Description of Works: Approval of reserved matters following outline consent
LU/229/10/ for appearance, landscaping, layout & scale for 84
No. dwellings

PLANNING REF: LU/201/16/RES – WINDROOS, LITTLEHAMPTON

AMENDED APPLICATION - CONSULTATION RESPONSE

**COMMENTS FROM NIGEL BALDWIN - 22 March 2017- HOUSING STRATEGY
AND ENABLING MANAGER – ARUN DISTRICT COUNCIL**

CLIENT	STUART & MARCIA LYONS
PROJECT	WINDROOS, LITTLEHAMPTON
TITLE	2 BEDROOM FLATS - FLOOR PLANS

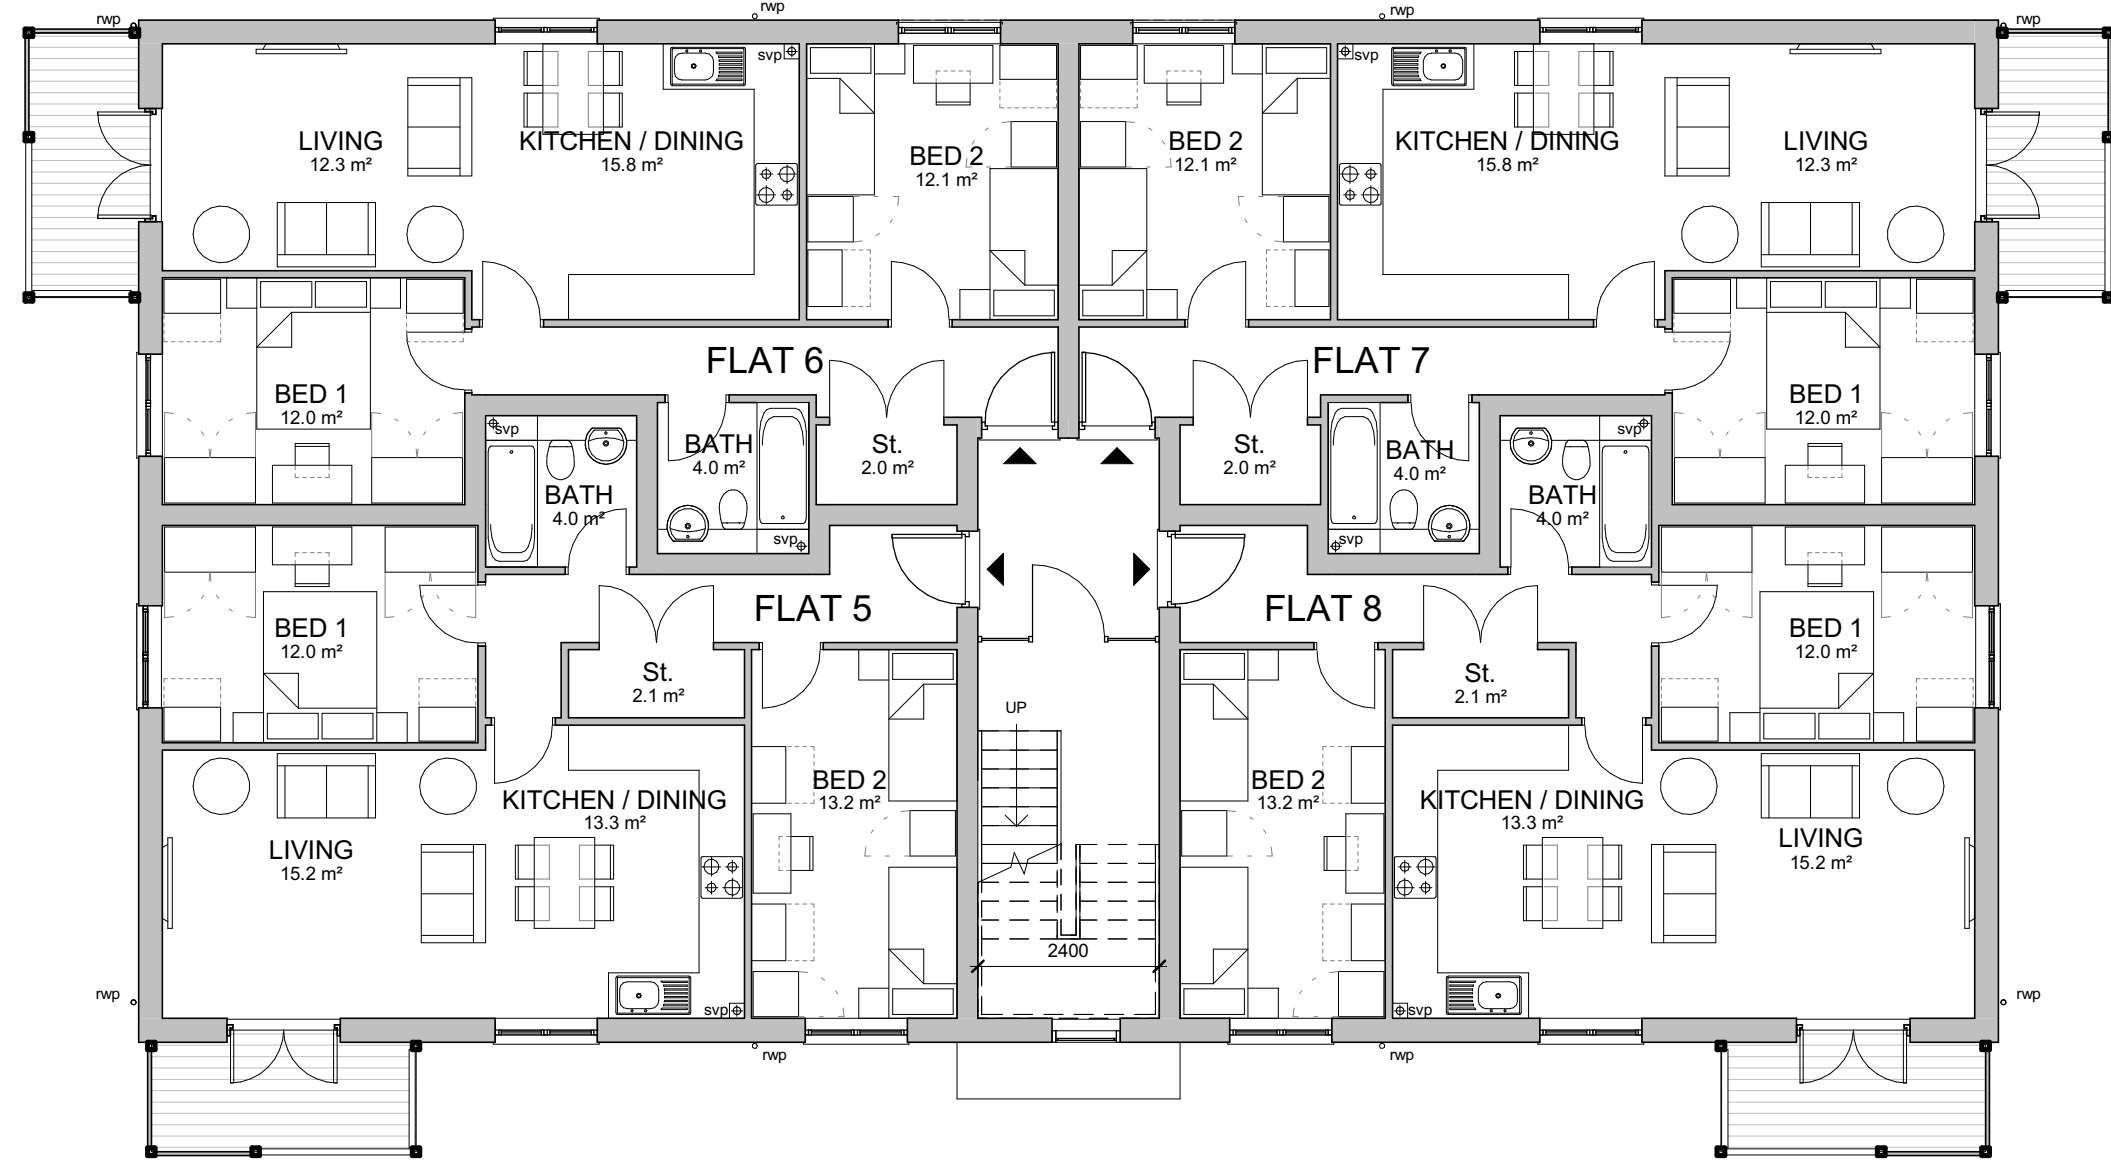
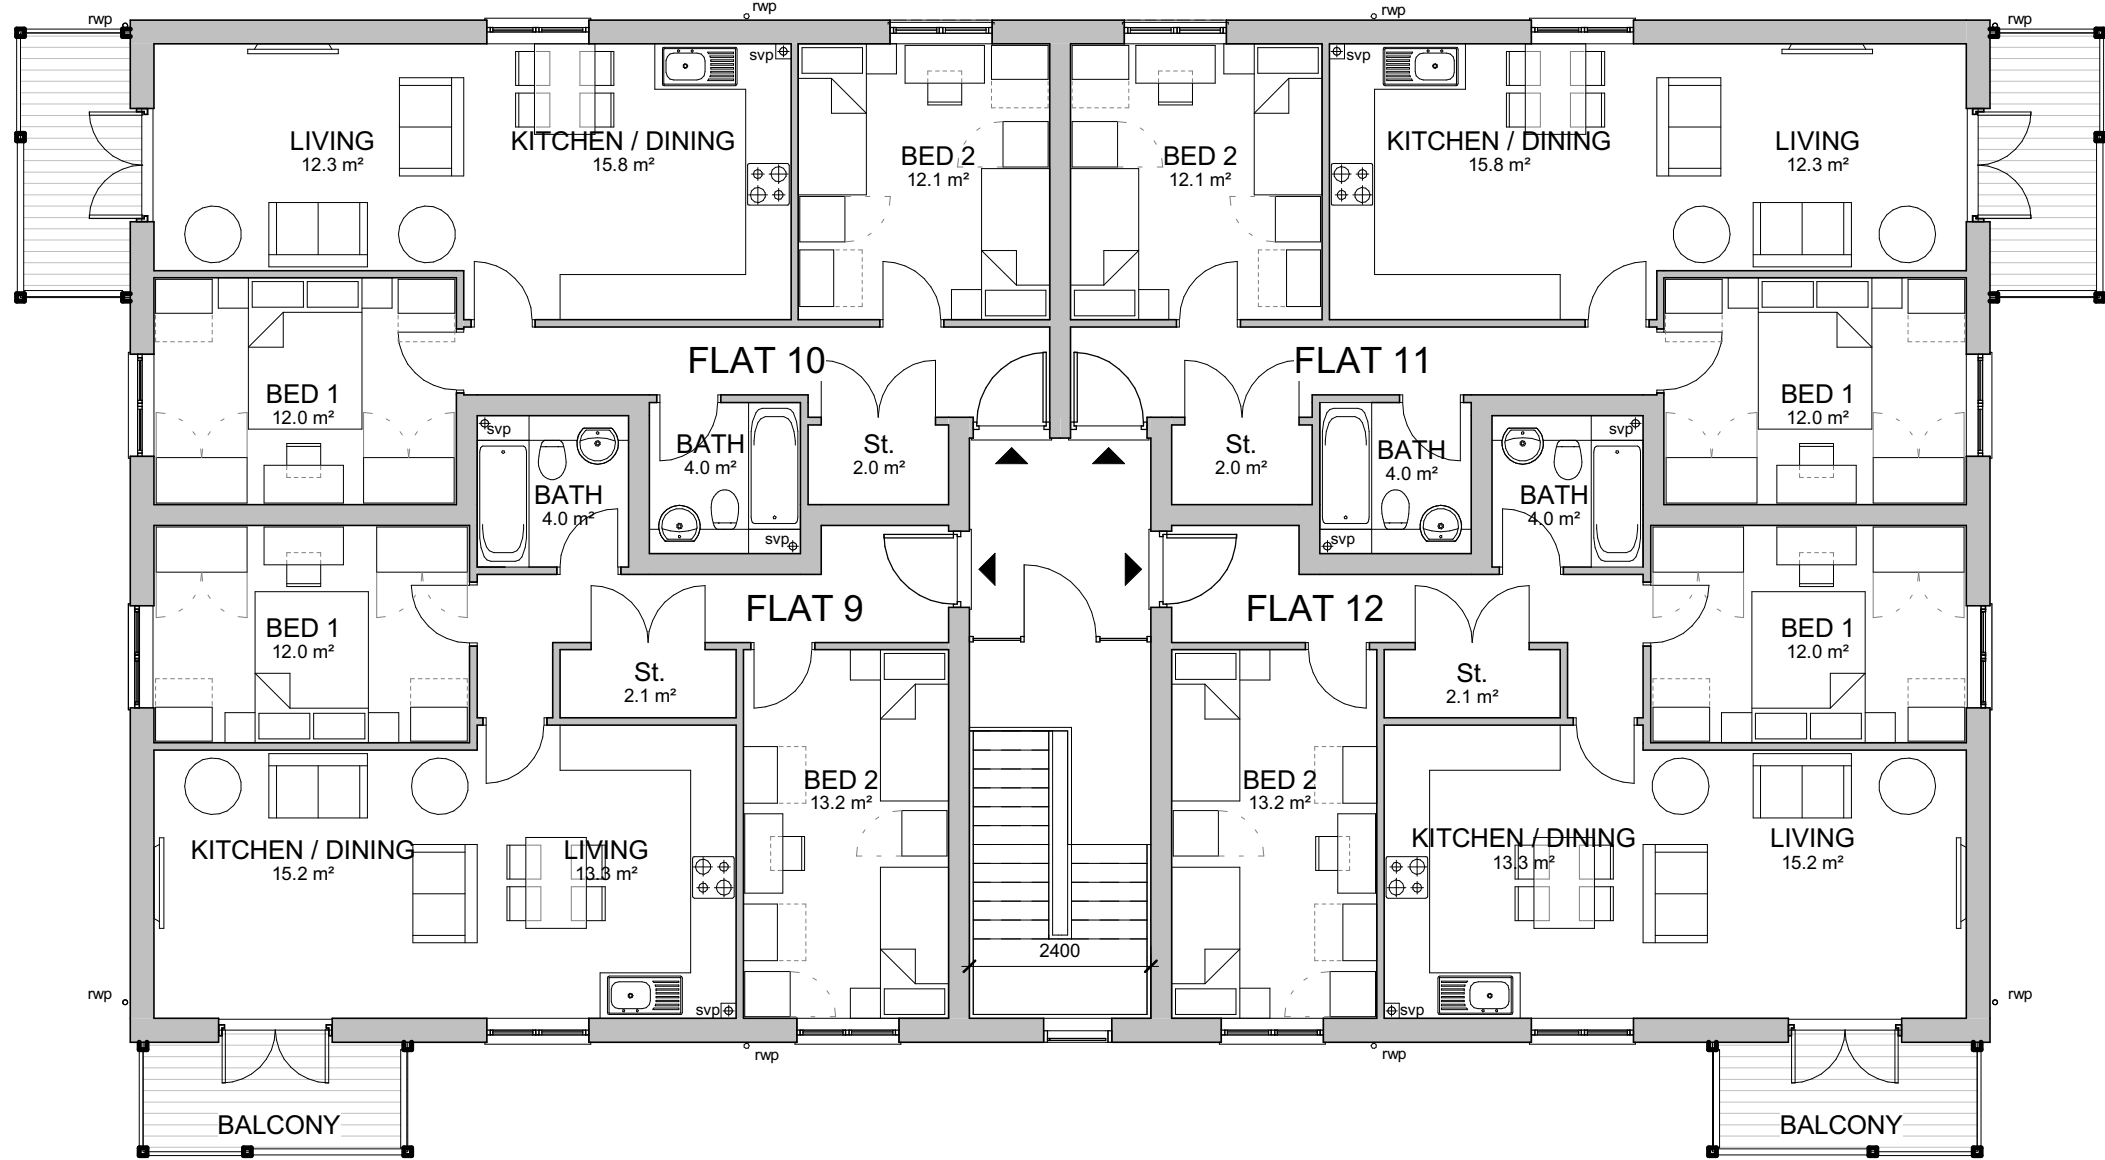
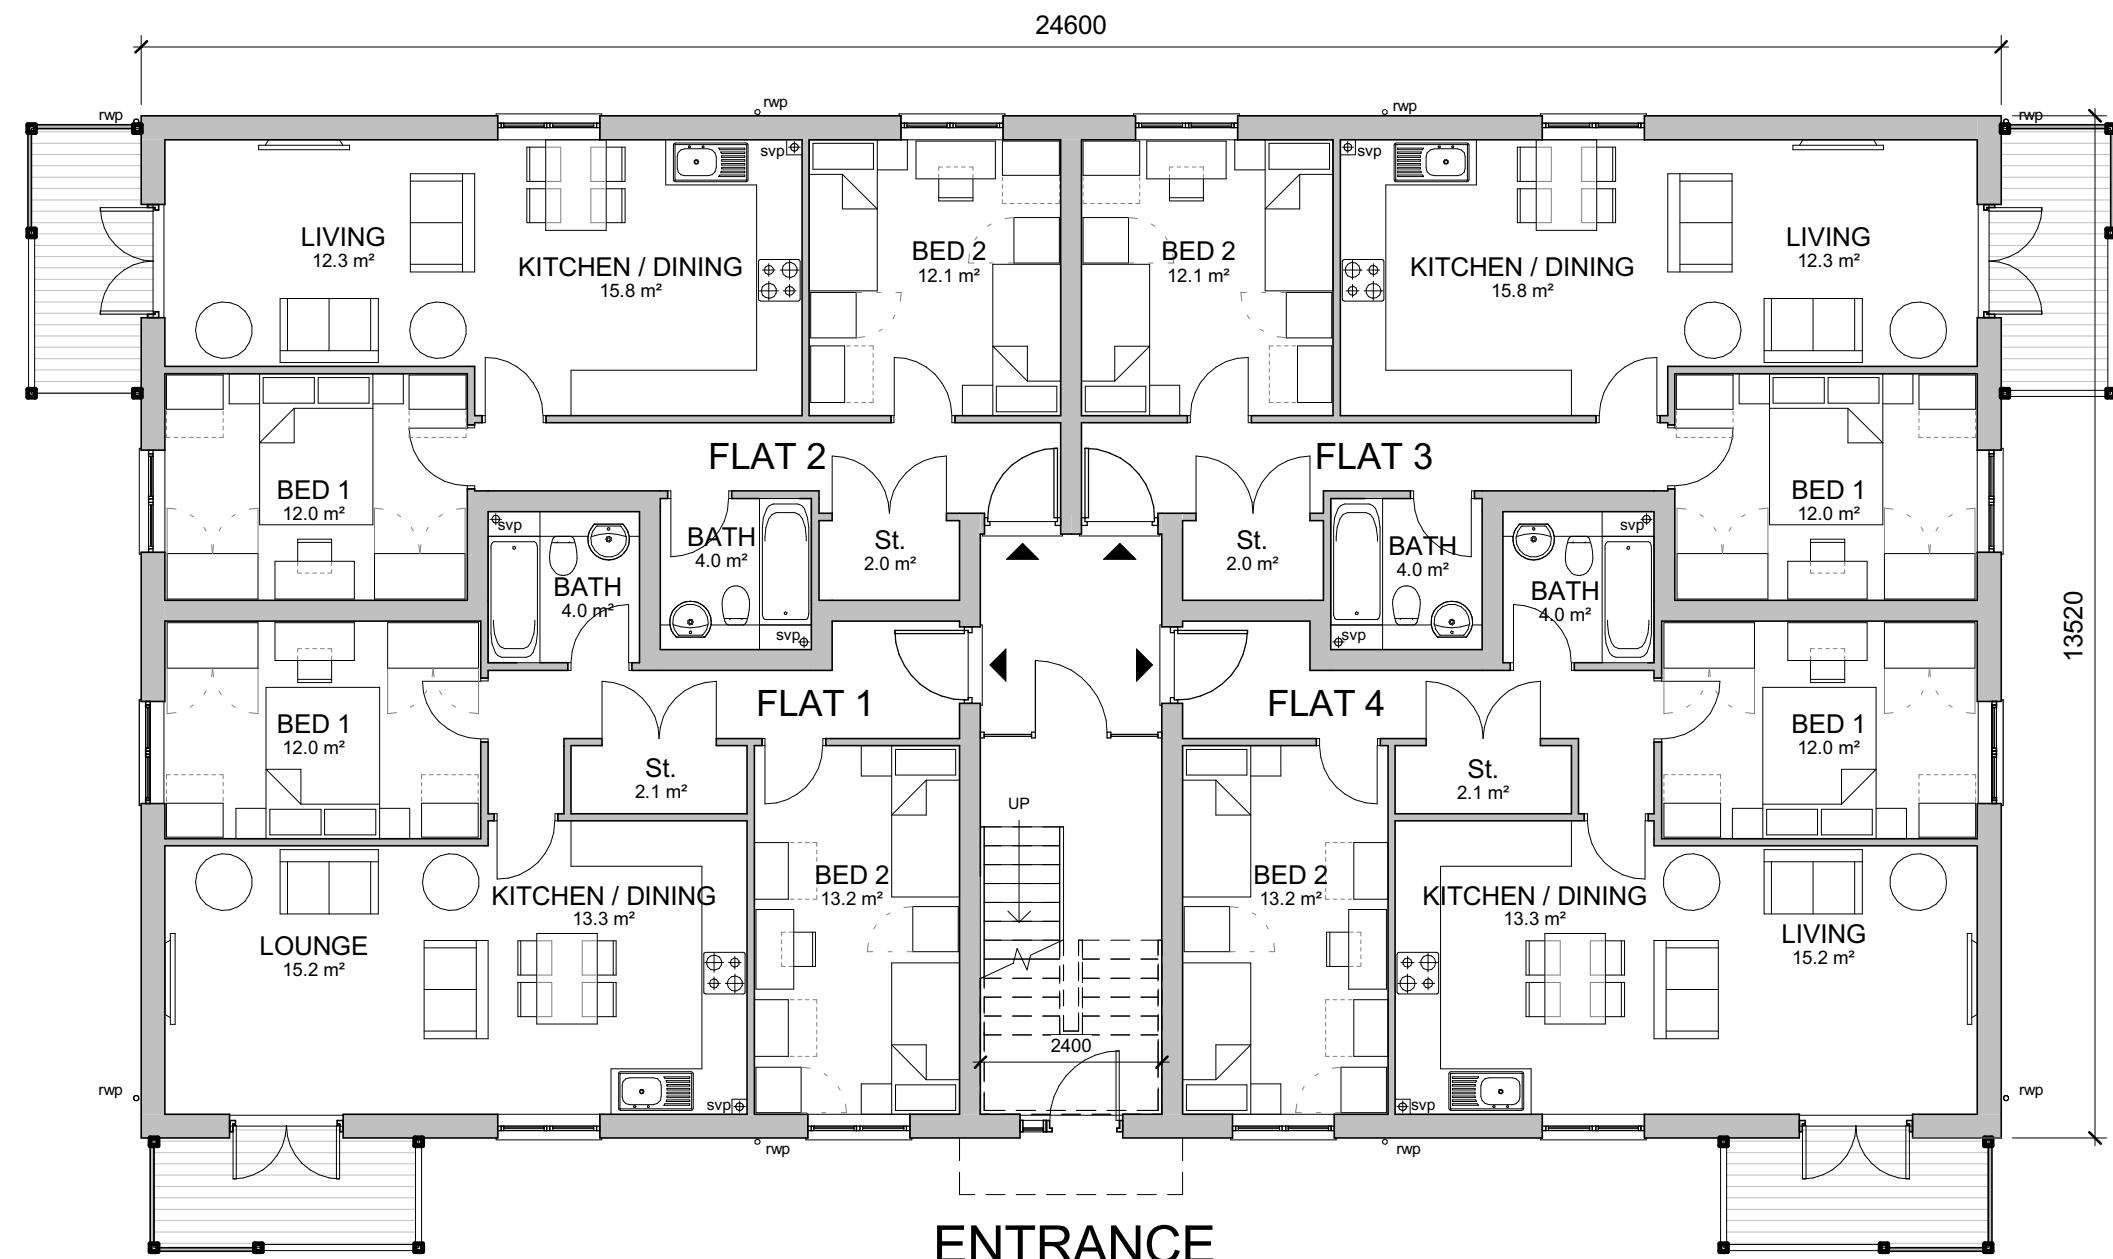
- The applicants should continue to engage with one of the Arun preferred providers of affordable housing in order to deliver the affordable housing.
- There appears to be very little space around the bed in Bedroom 1 of the 2 bed flats &
- The open plan nature of the kitchens in the 2 bed properties does not allow them to be secured and this can be a safety issue.
